# CITY OF PORTLAND

# BUILDING PERMIT

Job ID: 2012-04-3820-SF

has permission build a 26 by 32 foot Single Family Residence.

Drawing file: 2012-04-3820-SF / Sumac St Floor Plan, Cross Section.pdf

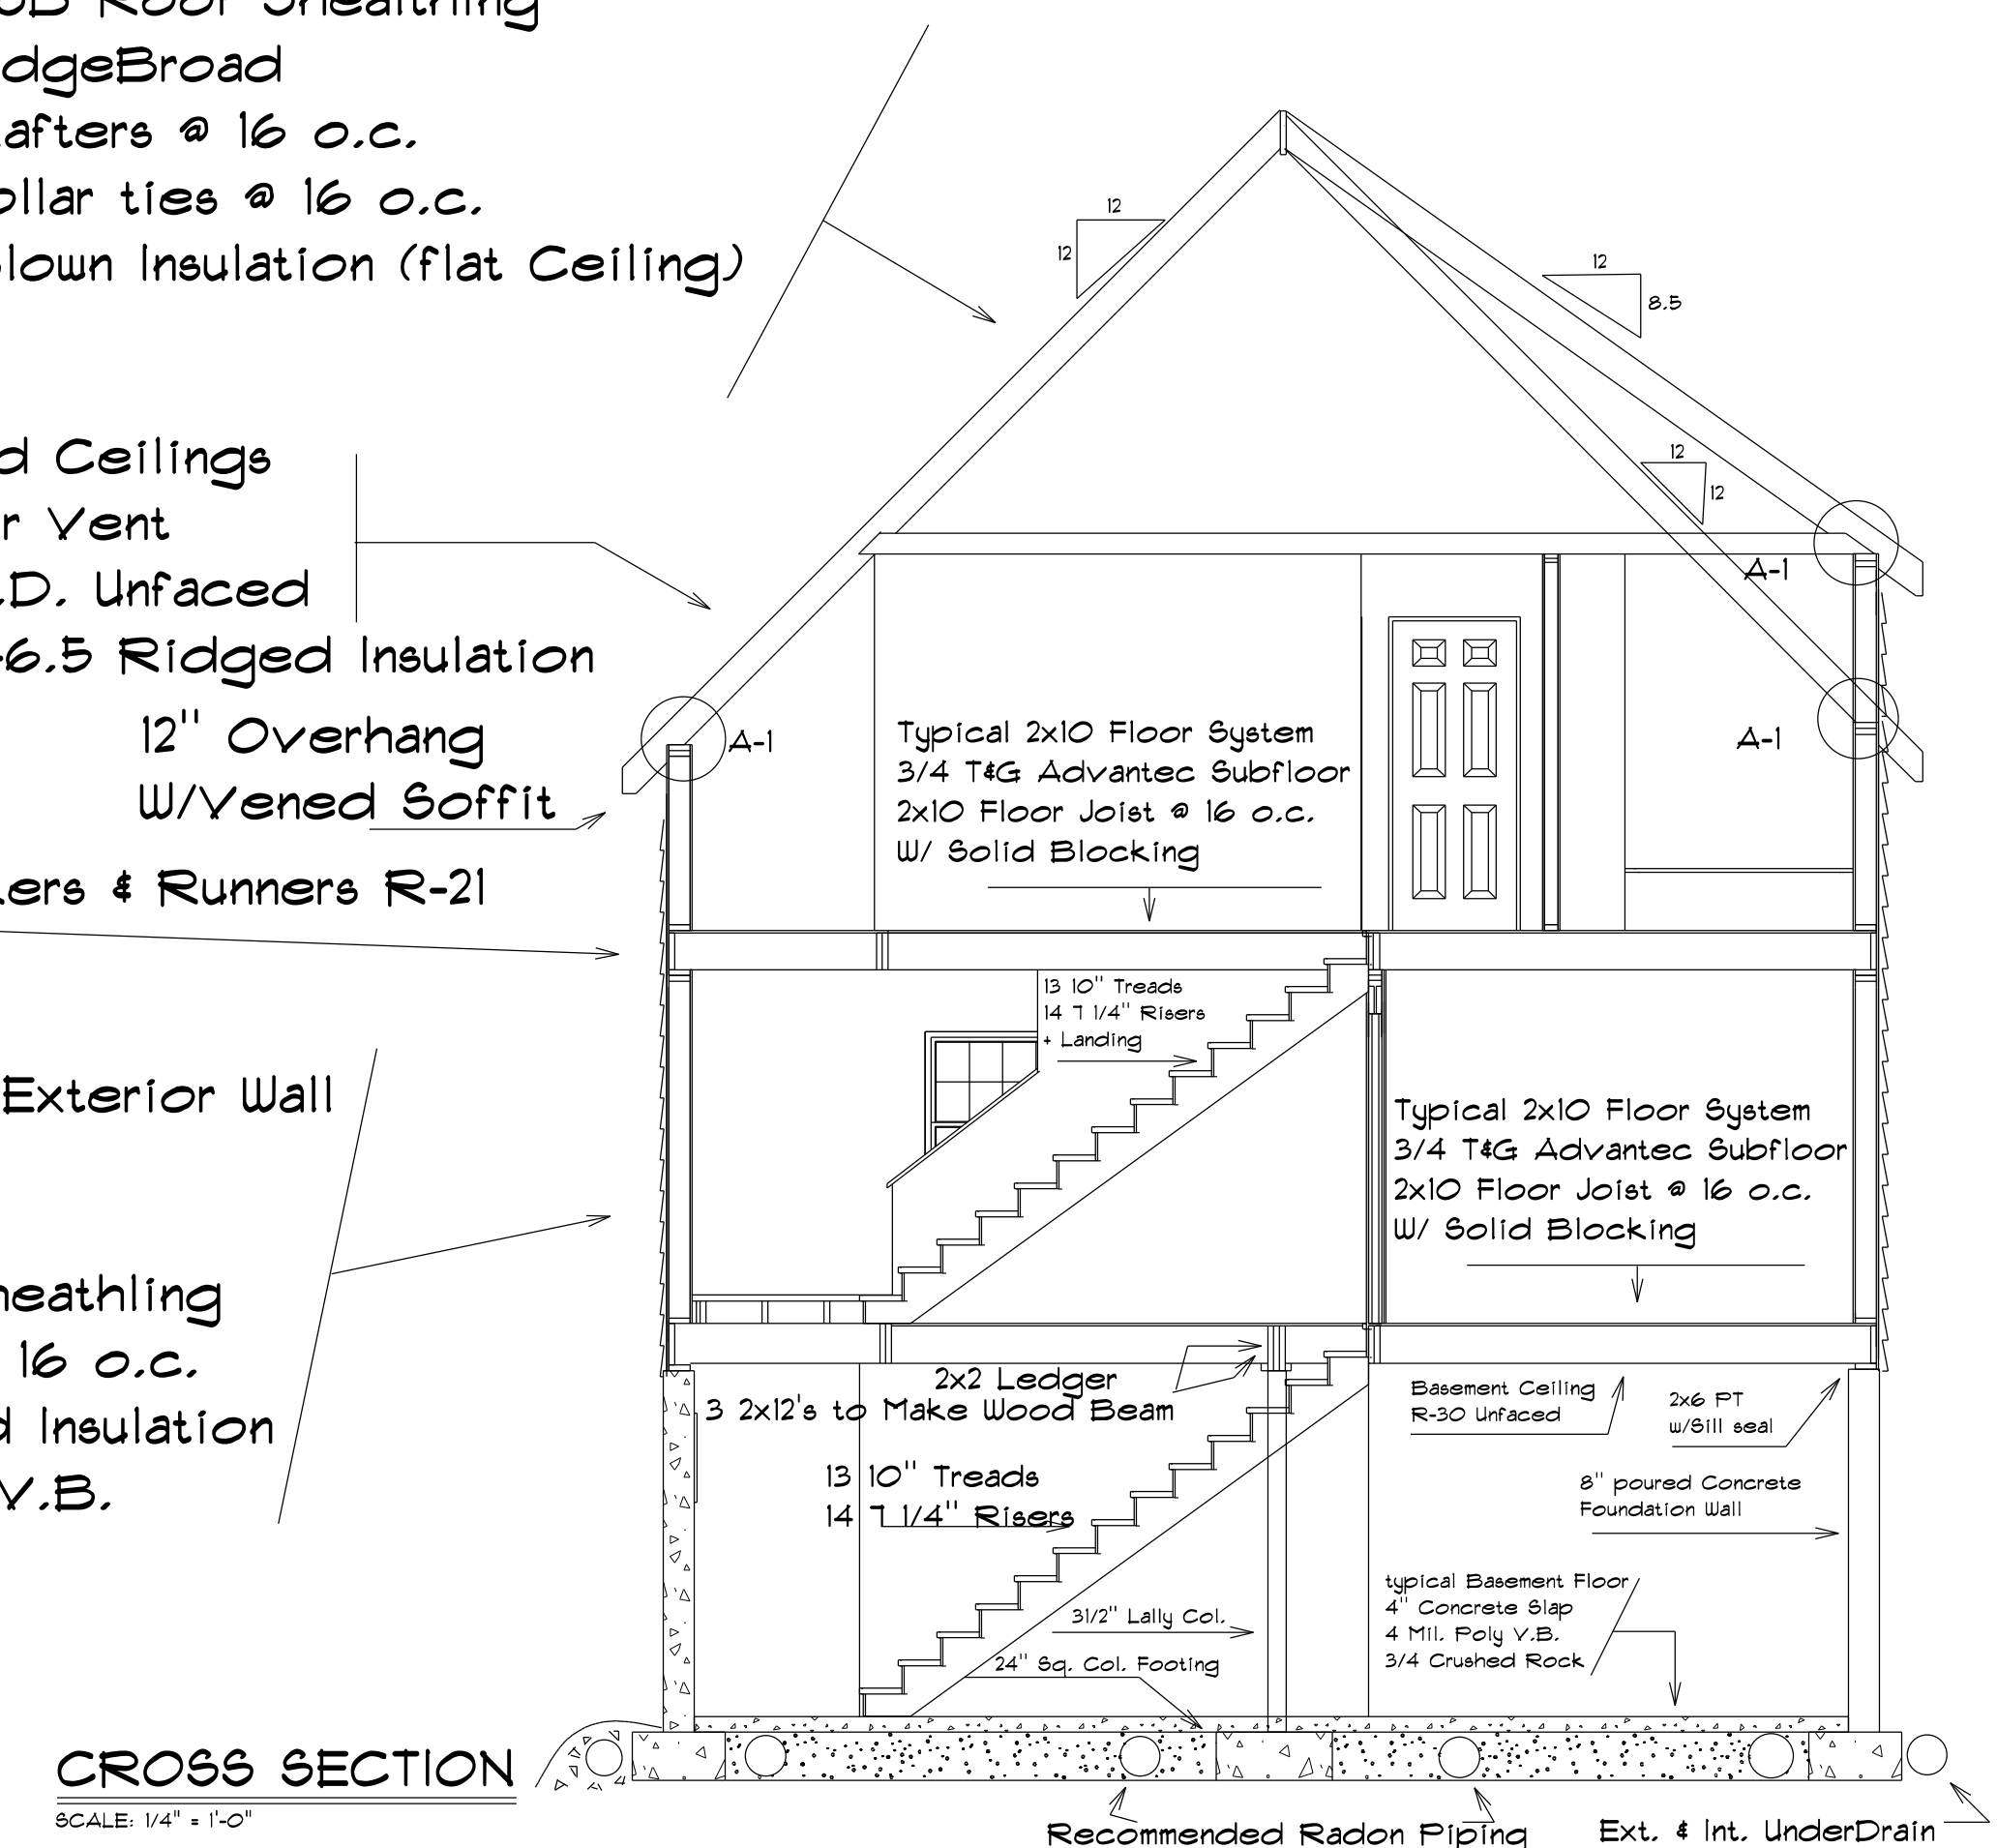
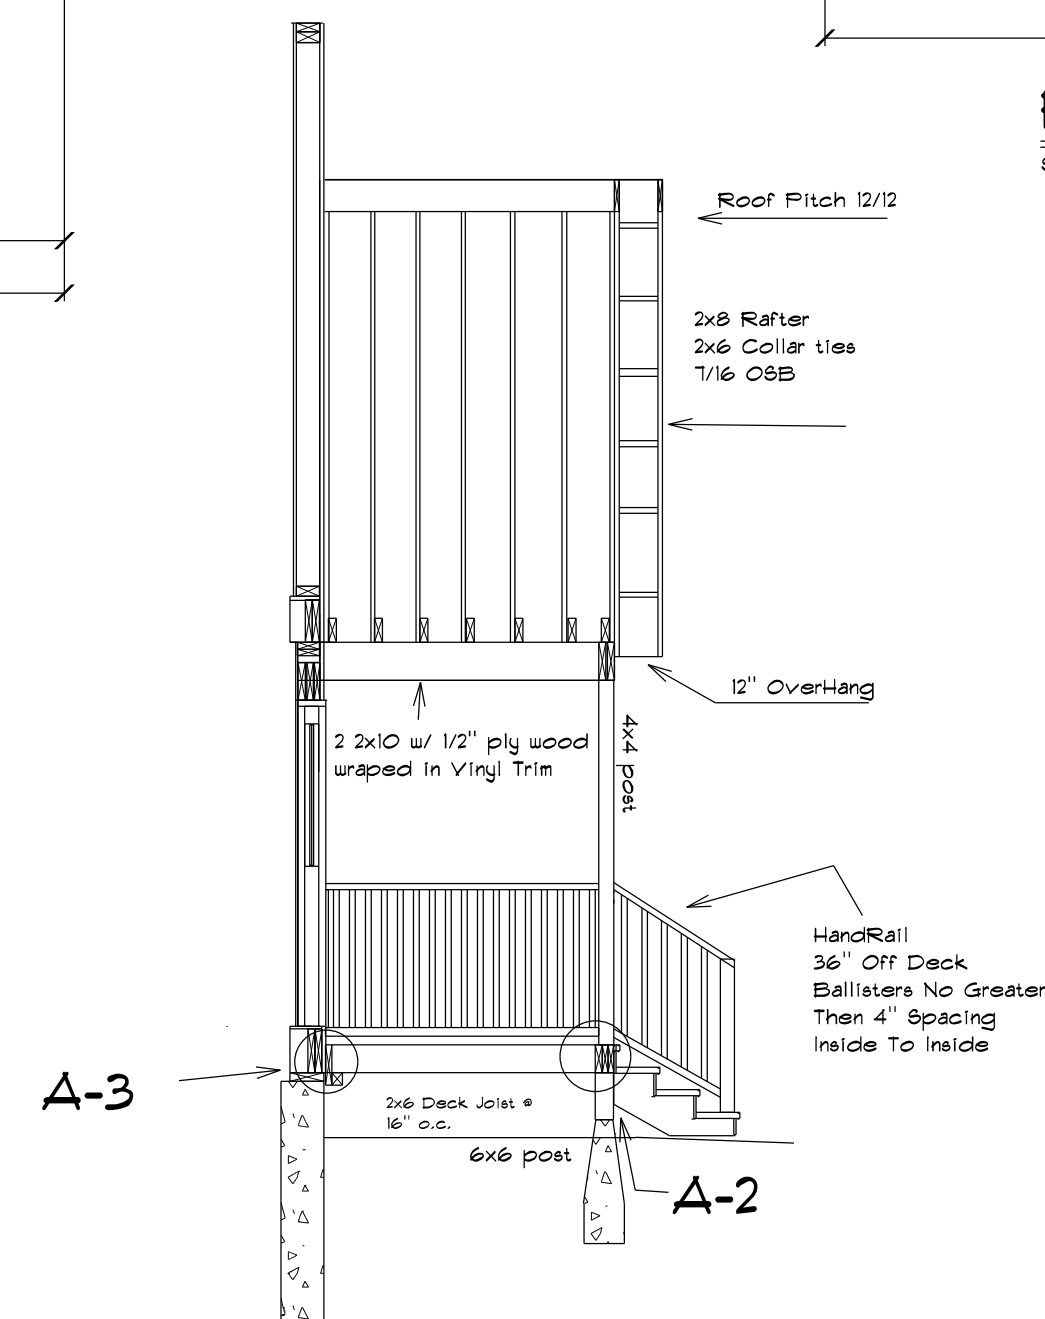
11. Owner is amending plans for a Structural Ridge in compliance with Section R802.3 & R802.3.1 of MUBEC.
12. R502.6 Bearing. The ends of each joist, beam or girder shall have not less than 1.5 inches of bearing on wood or metal and not less than 3 inches on masonry or concrete except where supported on a 1-inch-by-4-inch ribbon strip and nailed to the adjacent stud or by the use of approved joist hangers.

Please submit specification (From your Supplier) for the Structural Ridge amendment, and how it will be posted to the foundation.

*Note: Enclosed accessible space under stairs shall have walls, under-stair surface and any soffits protected on the enclosed side with 1/2-inch gypsum board. Attached is our minimal requirements for interior Girder spans- the plan specification do not appear to meet our minimal building code requirements. JGR.*
